**WEST SUSSEX COUNTY COUNCIL
PLANNING SERVICES CONSULTATION**

SUBJECT: BN/28/17/RES

Approval of reserved matters following outline consent BN/32/15/OUT relating to appearance, landscaping, layout & scale for erection of 38 No. dwellings including open space, landscaping & new access.

Land R/O Lillies, Yapton Road, Barnham, PO22 0AY

JOB NO.	DRAWING NO.	REV
MATT151202	SL.01	P5

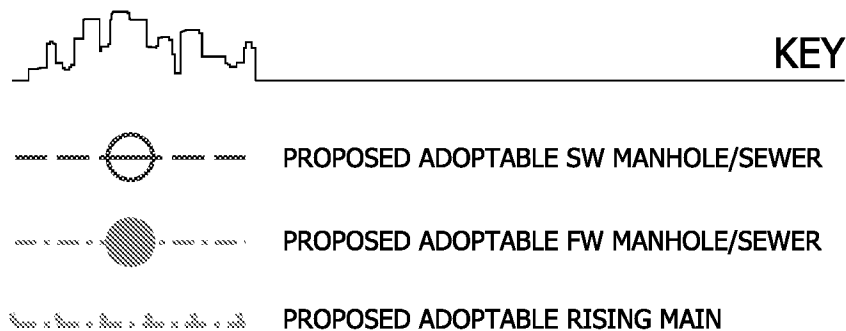
The parking strategy contained with the Design and Access statement indicates that visitor parking is provided for throughout the site. However, it is unclear from the accompanying plan where this parking is located. Spaces shown on the plan appear to be numbered and allocated to specific properties. It is recommended that an assessment be undertaken against with the WSCC Parking Demand Calculator to determine the suitability of the parking provision when compared to the anticipated demand, and that the clarification is provided on the strategy in respect of the number, and location of, visitor and unallocated parking spaces.

- The straight alignment of the road and clear forward visibility may increase speeds along the main spine road. Consideration may want to be given to measures to reduce speeds, such as localised narrowing along the spine road
- Visibility splays of 2.4m x 25m should be provided at internal junctions, kept clear of landscaping above a height of 600mm and below a height of 2000mm
- Internal garage dimensions should be a minimum dimension of 3m x 6m
- Car parking spaces should be a minimum dimension of 2.4m x 4.8m
